Your Ref: **32111000**
Our Ref: **G pre00220/2019**
(Please quote in all related correspondence)

Re: Scoping Document for proposed replacement of 7 manned level crossings between Limerick Junction and Cork City on the Dublin-Cork Railway line.

Re: Replacement of 7 manned level crossings at Limerick to Cork Line.

Figure 16: Aerial view of site XC215 Shinanagh Ballynageragh, showing interpretation of geophysical survey

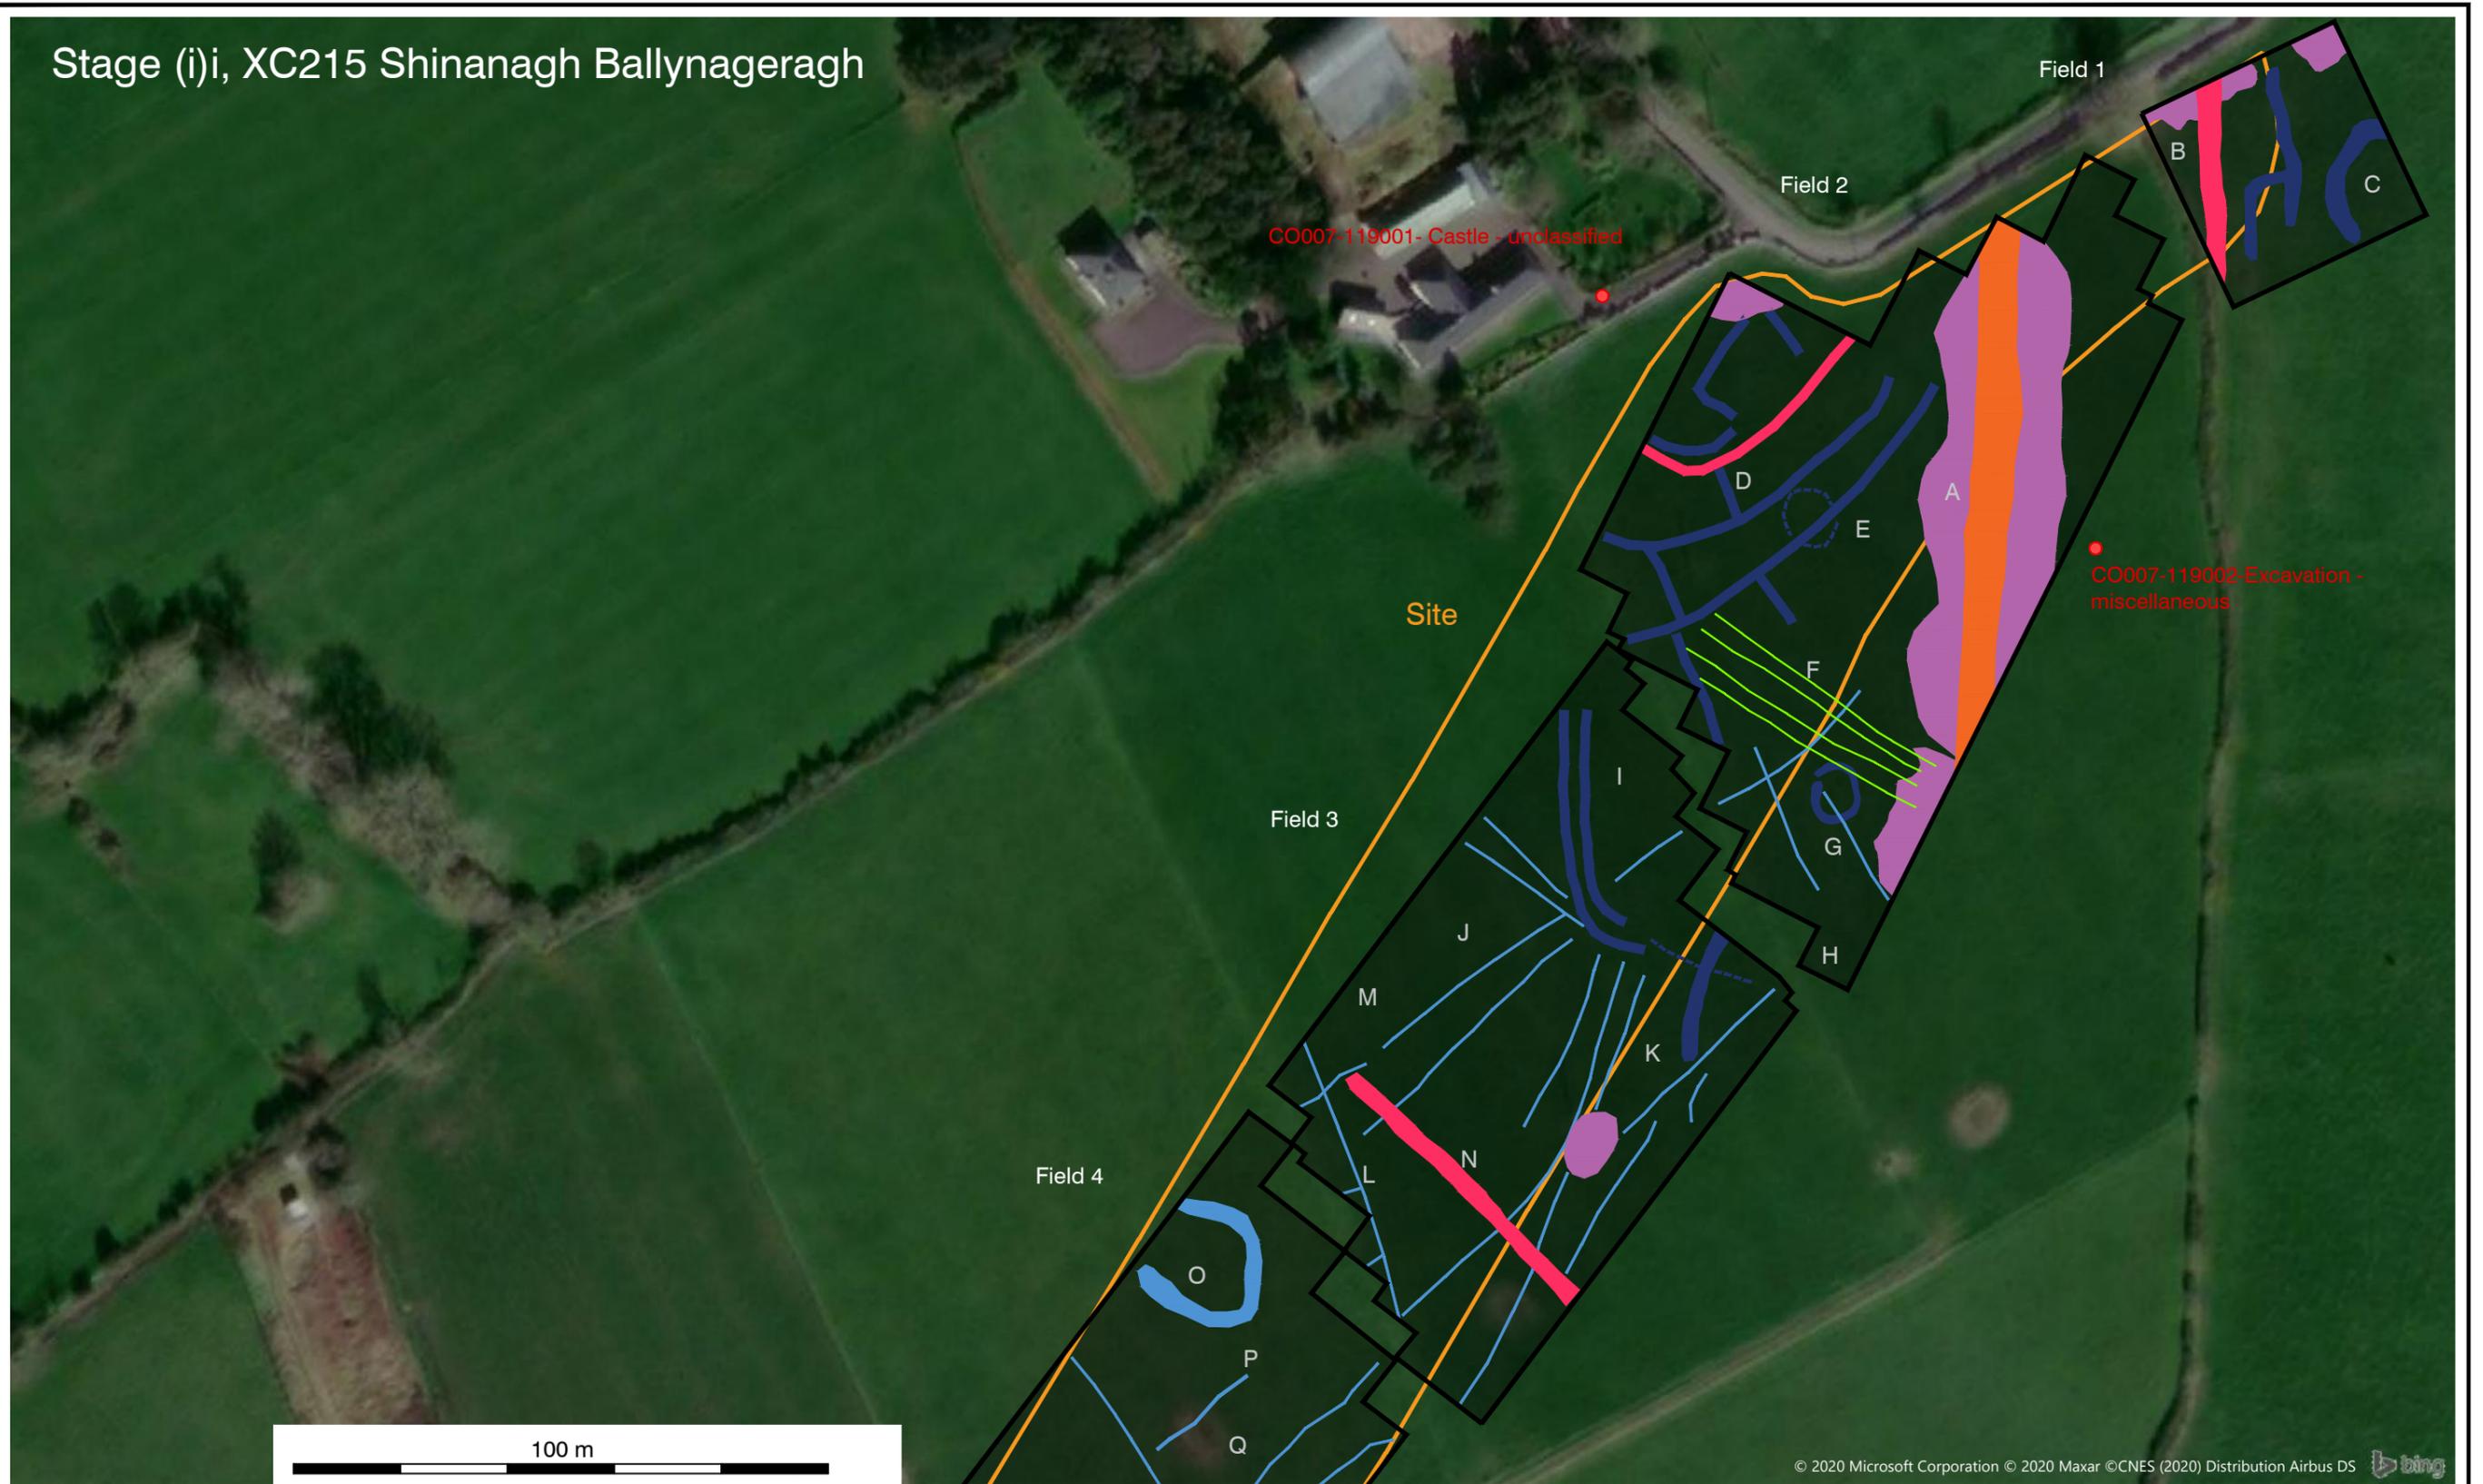
1. The Geophysical Survey carried out at Ballynageragh, Co. Cork (20R0239) has revealed extensive anomalies that are likely to be archaeological in nature. In this regard this site is not considered suitable for development, and should therefore be excluded from the project.
